planning ref:P/76/13
46 LAGOON ROAD PAGHAM PO21 4TQ

Enclosed is our form for non material amendment on our granted planning permission.

South West Elevation

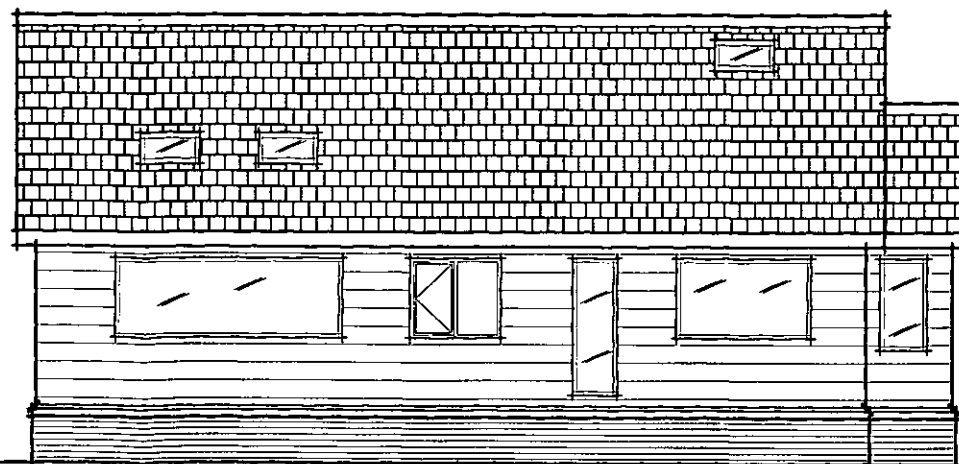
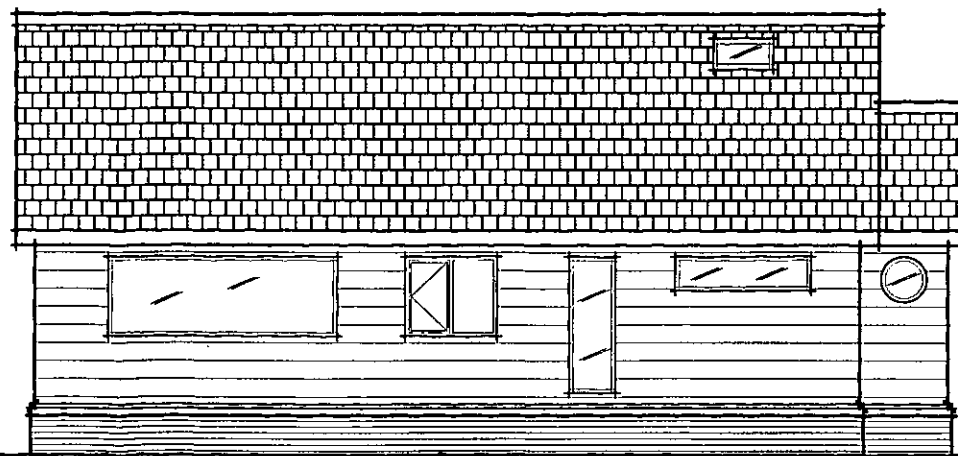
We enclose drawings which explain the amendments clearly . In all other instances the proposed building is exactly the same . We enclose 3 copies of the granted application , and 3 further copies of the amended drawings .

Please note that all changes are on the south west elevation of the building and do not overlook or are overlooked by anybody
